YOUR REF AW/90/18/HH 8 MERTON CLOSE.

I object to this extension to a 2 storey rear extension & 1st floor extension to front & side. Because it is an over development. This property was extended already AW/12/92. and is going to be to change for such a small close.

192-01C

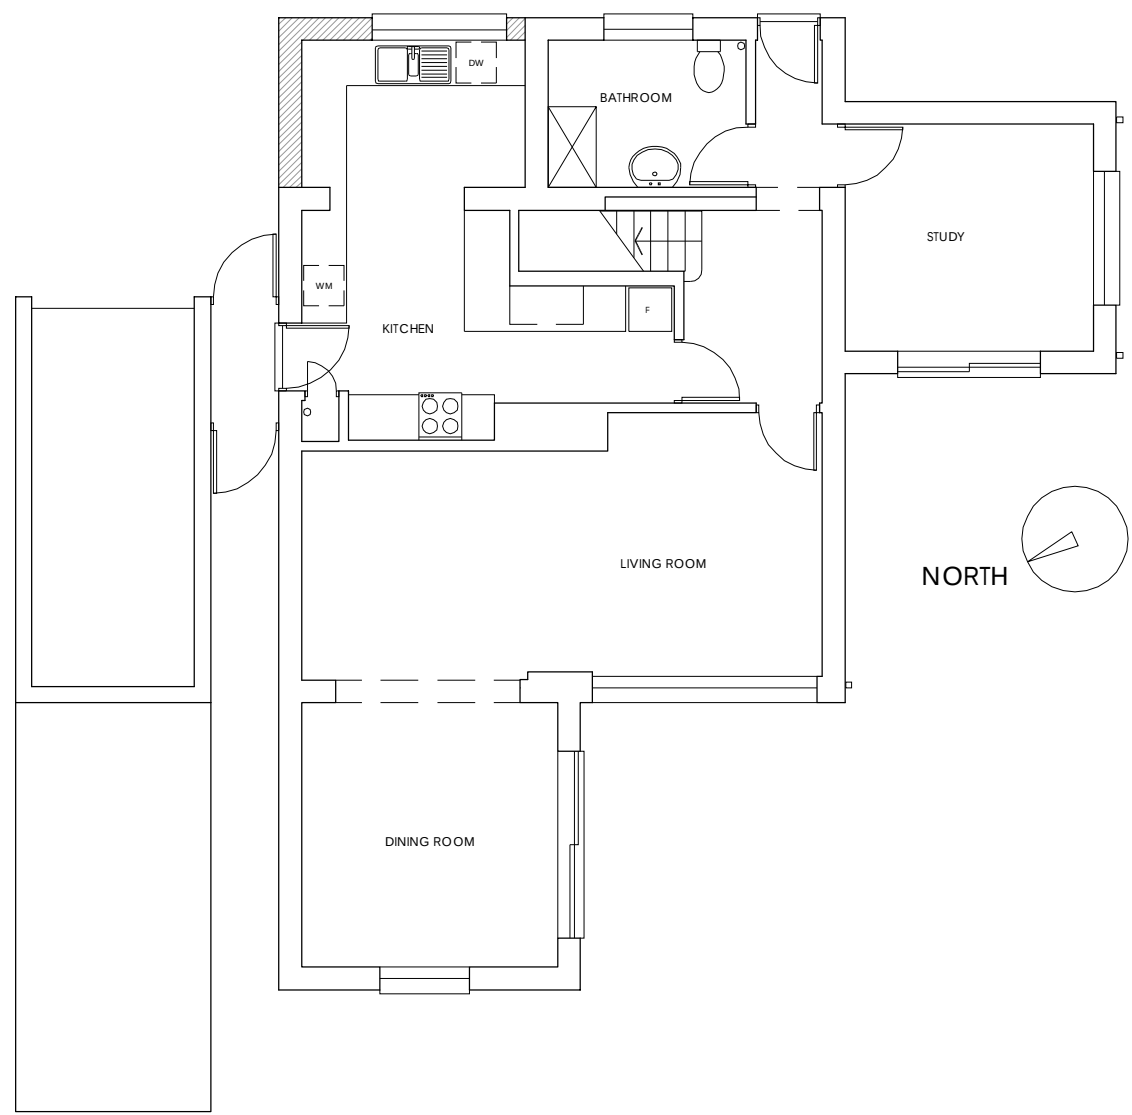
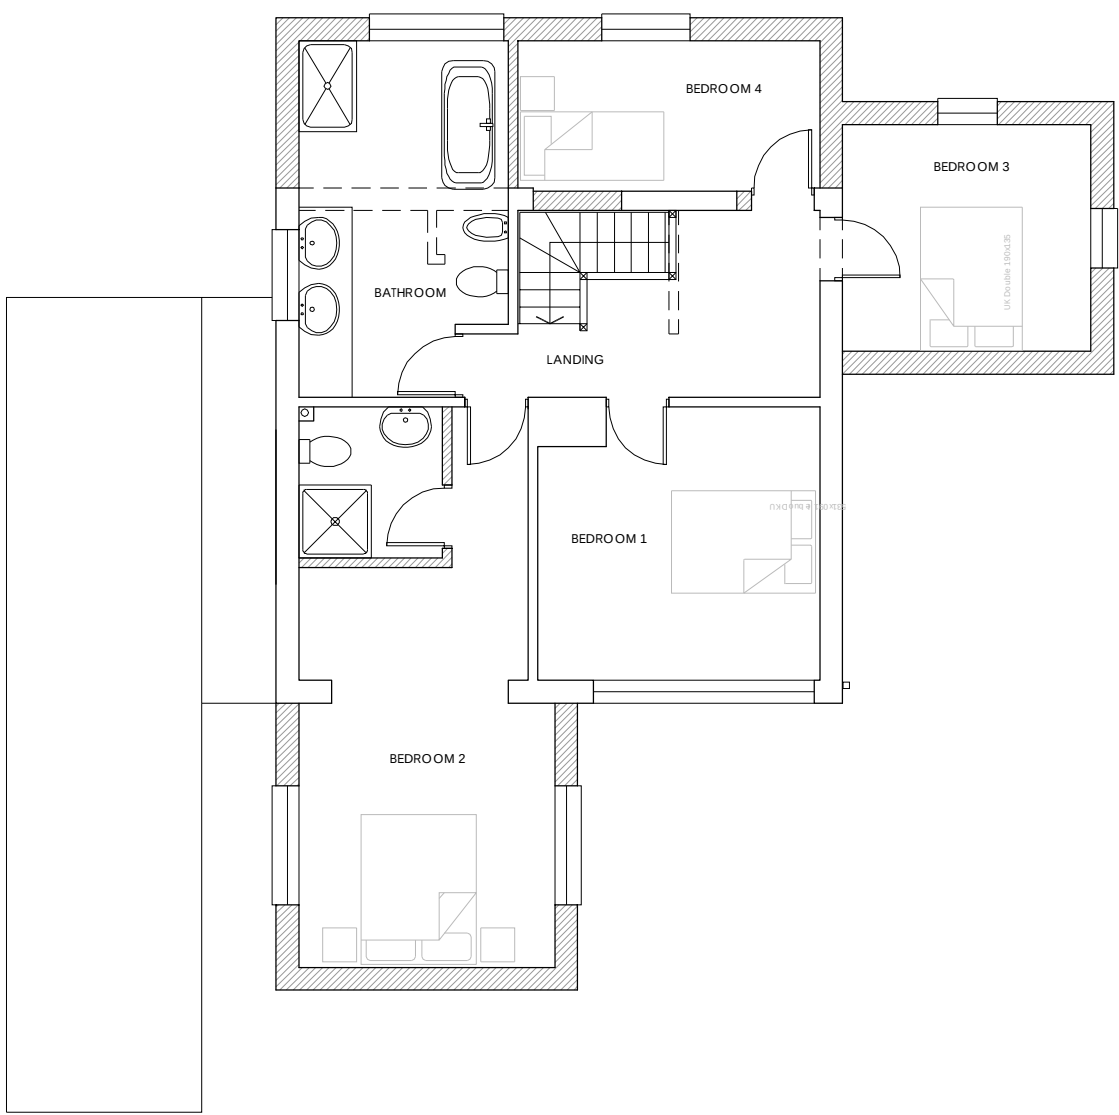
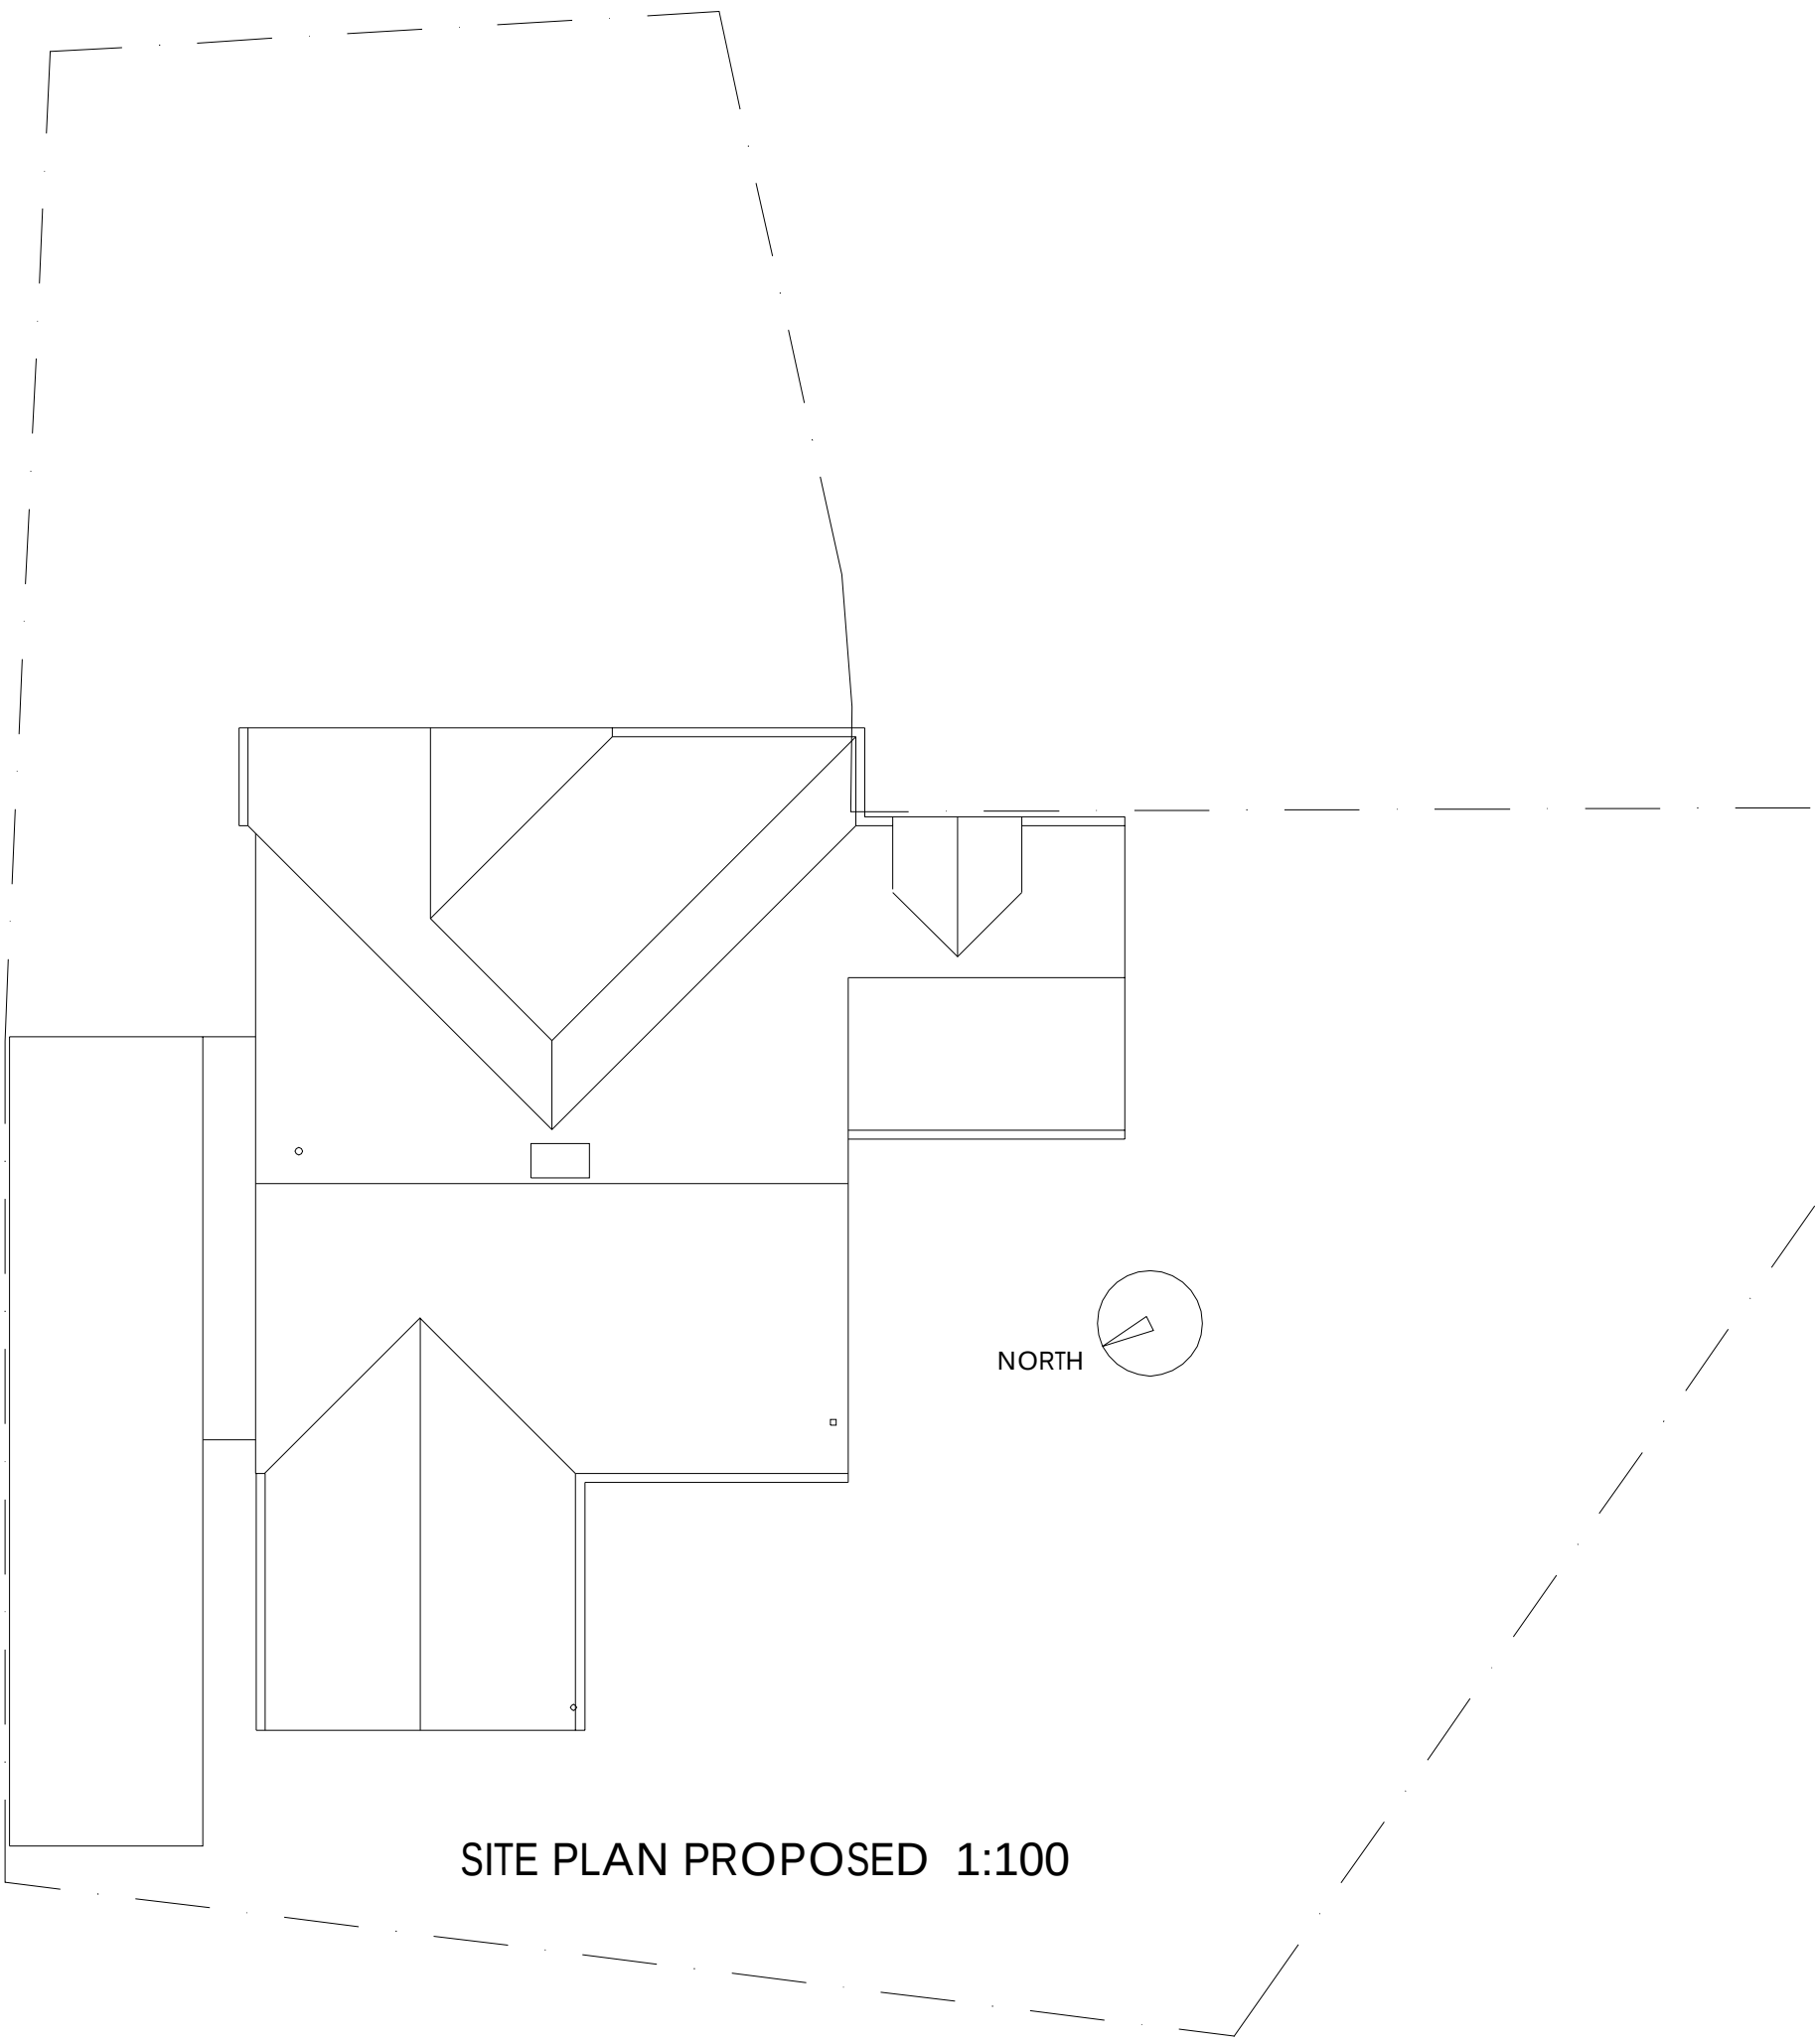
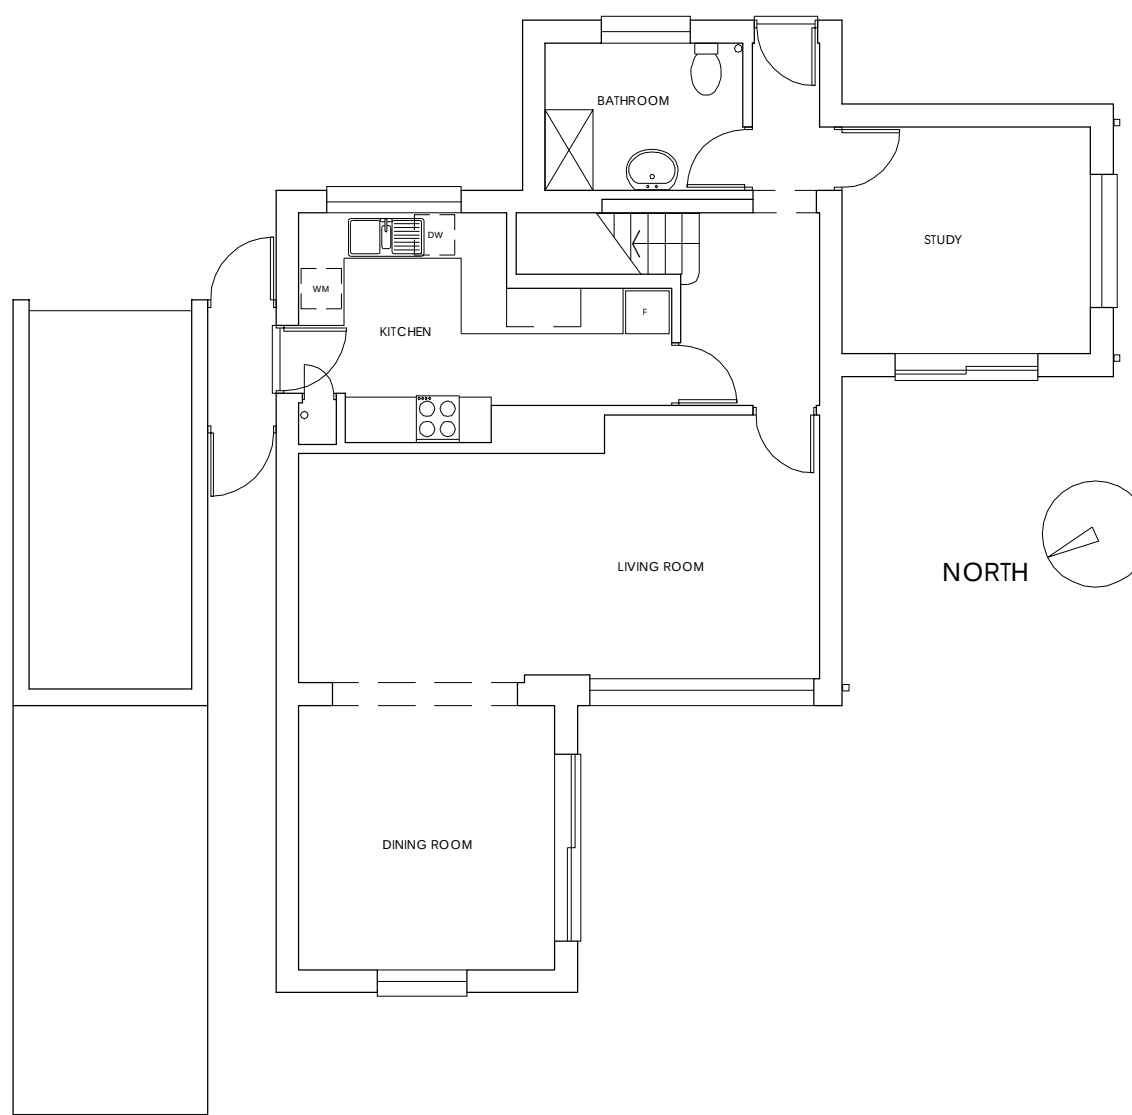
This extension will ^{have an} adverse. overshadowing, overlooking or overbearing effect on neighbouring properties (Policy DEV 19)

And will be out of scale and will add additional parking to a small close.
